Comments on the Applicant's Response to Deadline 3 Submissions [Part 9 - Noise] by William David Moore

Introduction

NMP1 - Time History Graph

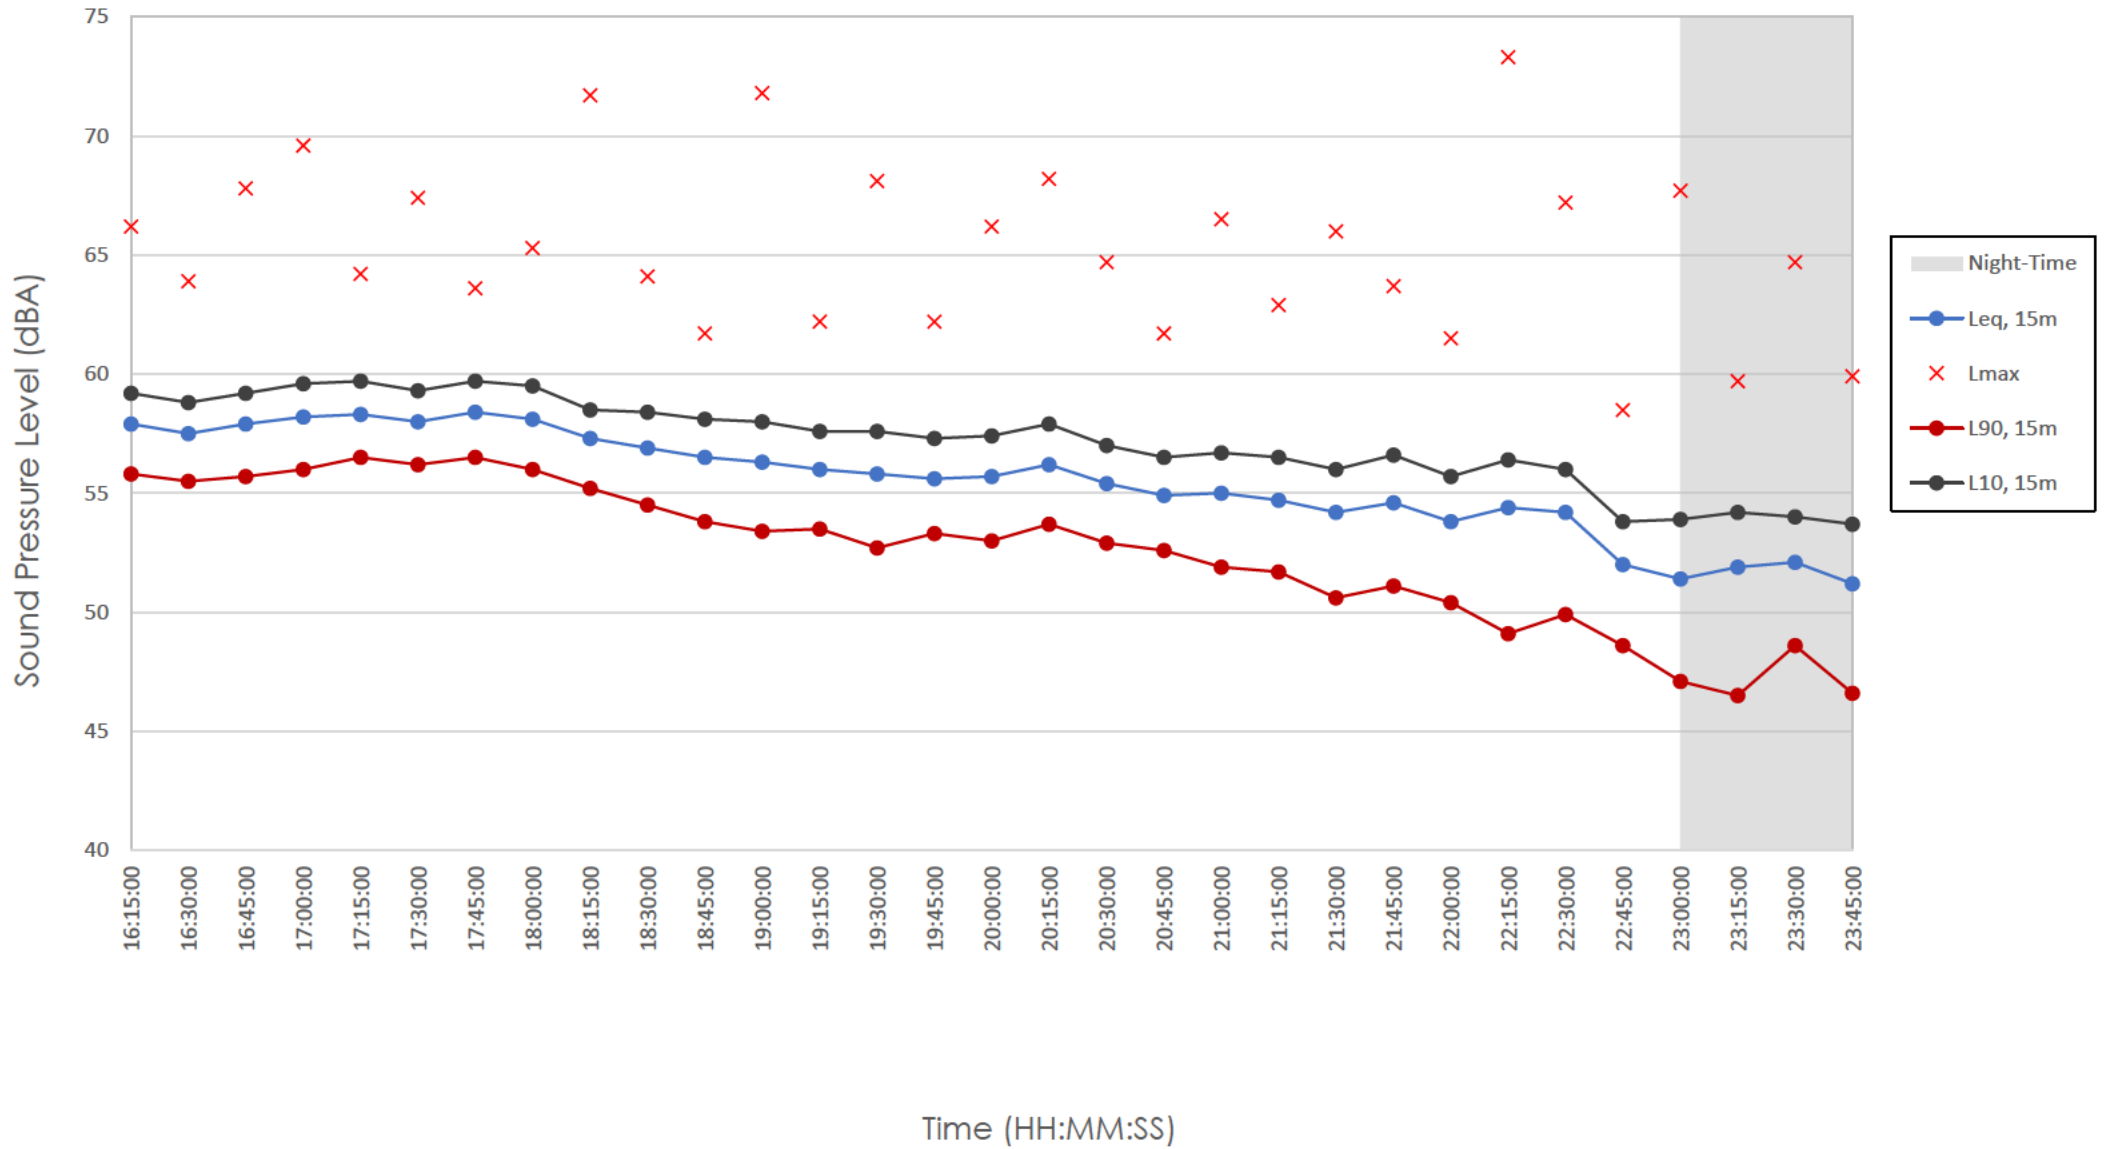
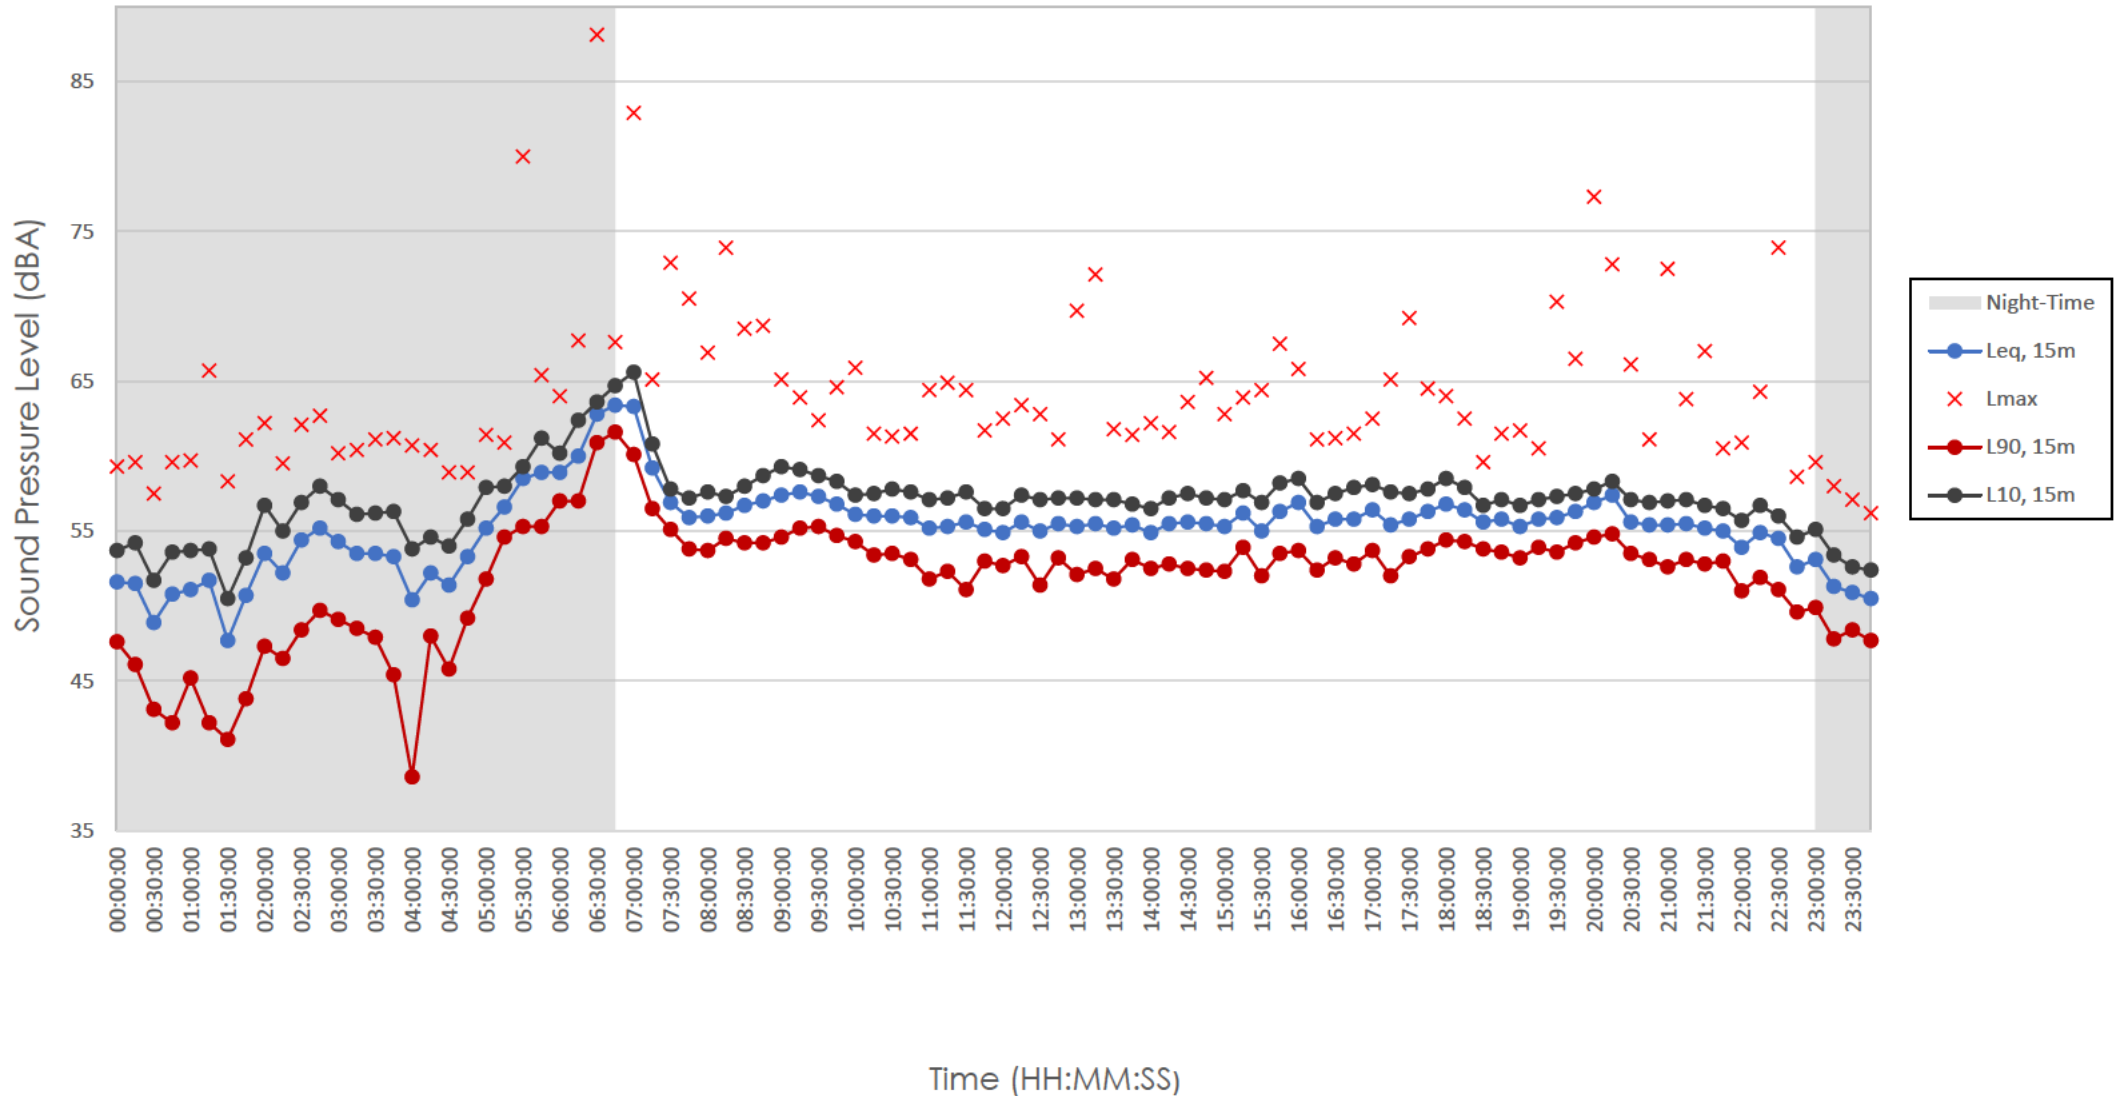
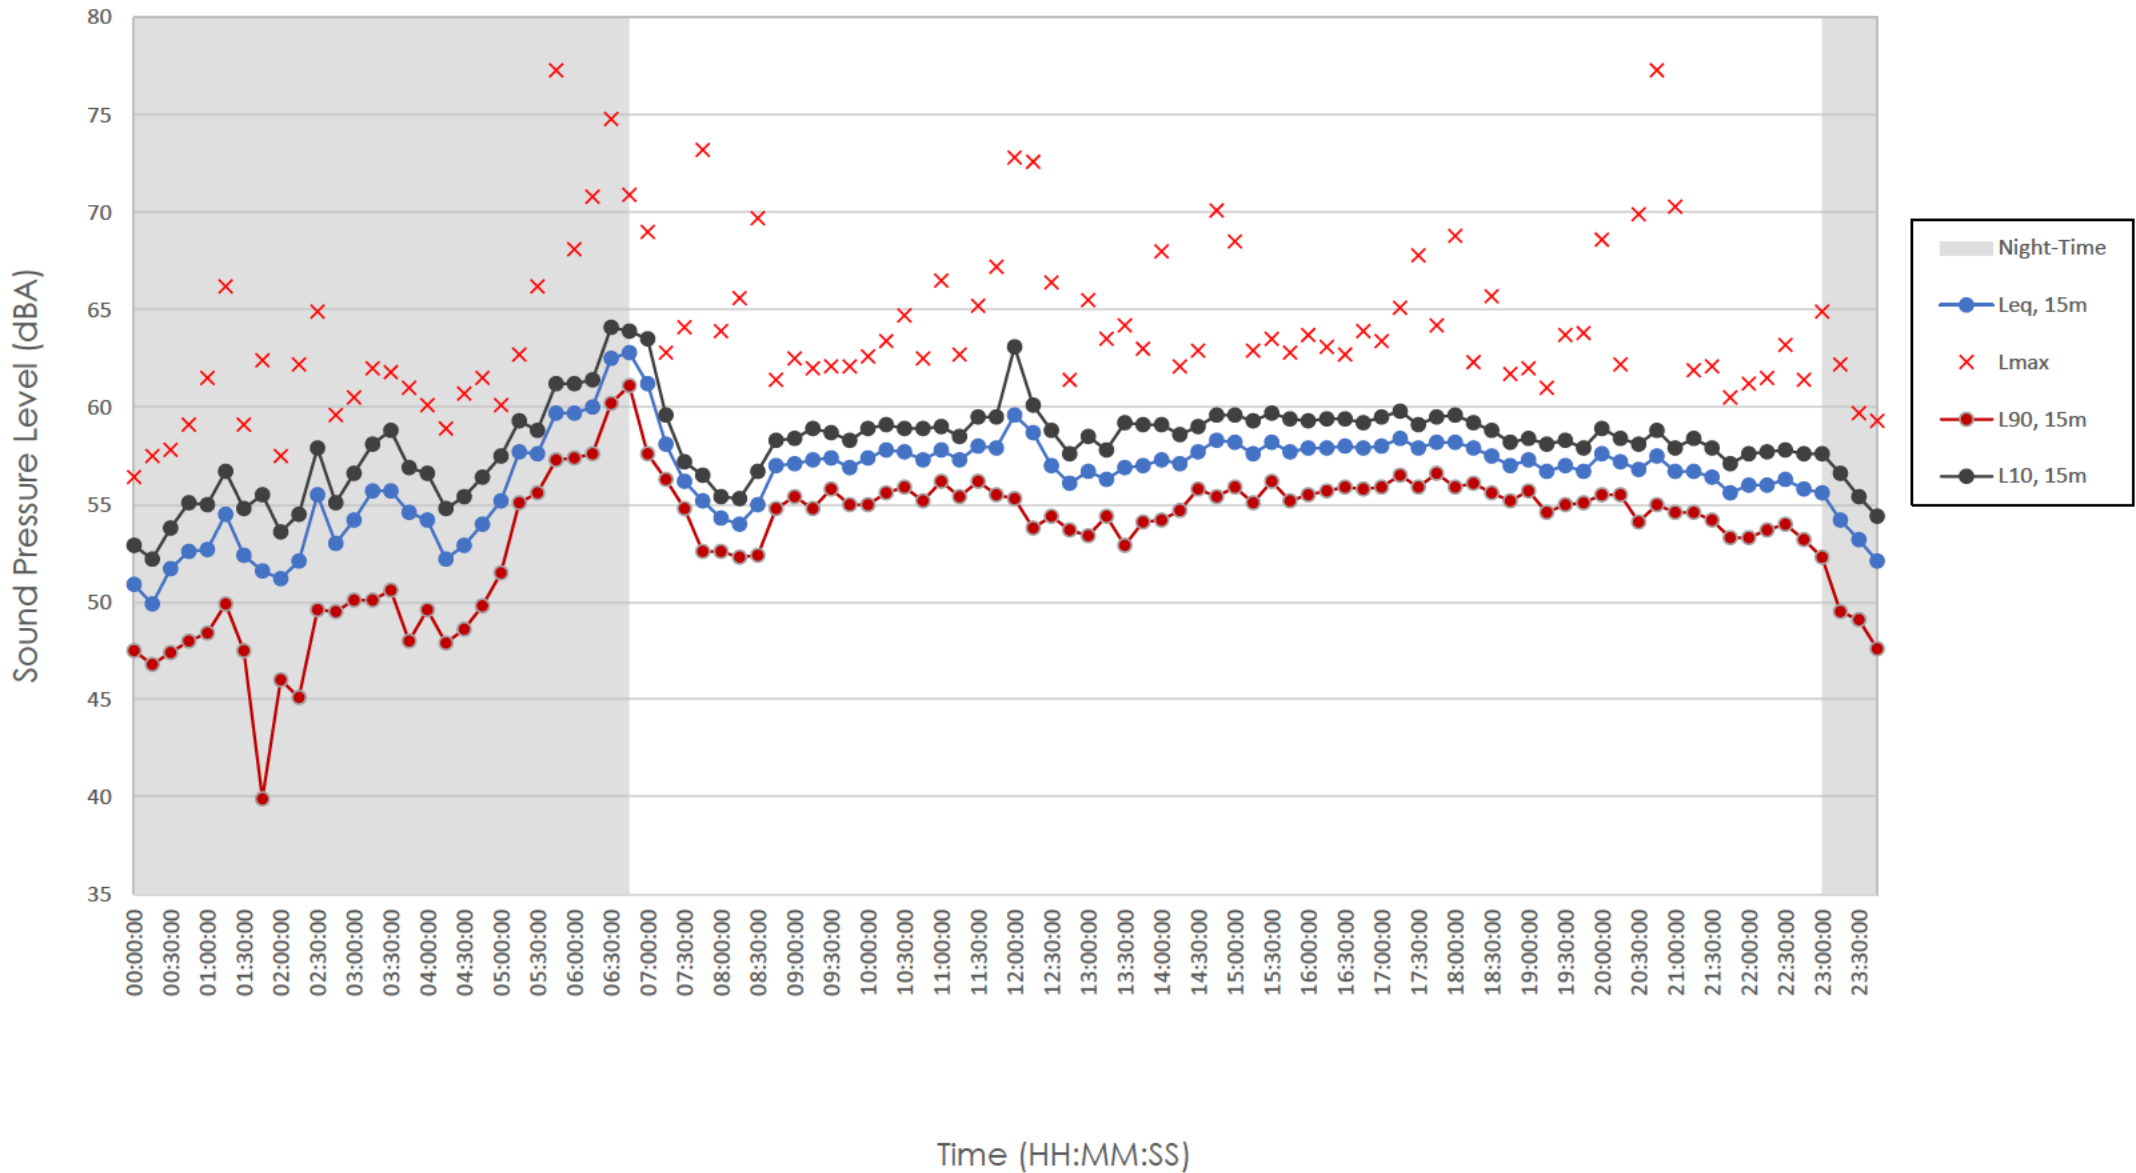
At NMP1, also in close proximity to the M69, the predicted daytime ambient sound levels were 5.4 dB above the levels measured and used in the report. The predicted night-time ambient sound levels were 6.4 dB above the levels measured and used in the report.
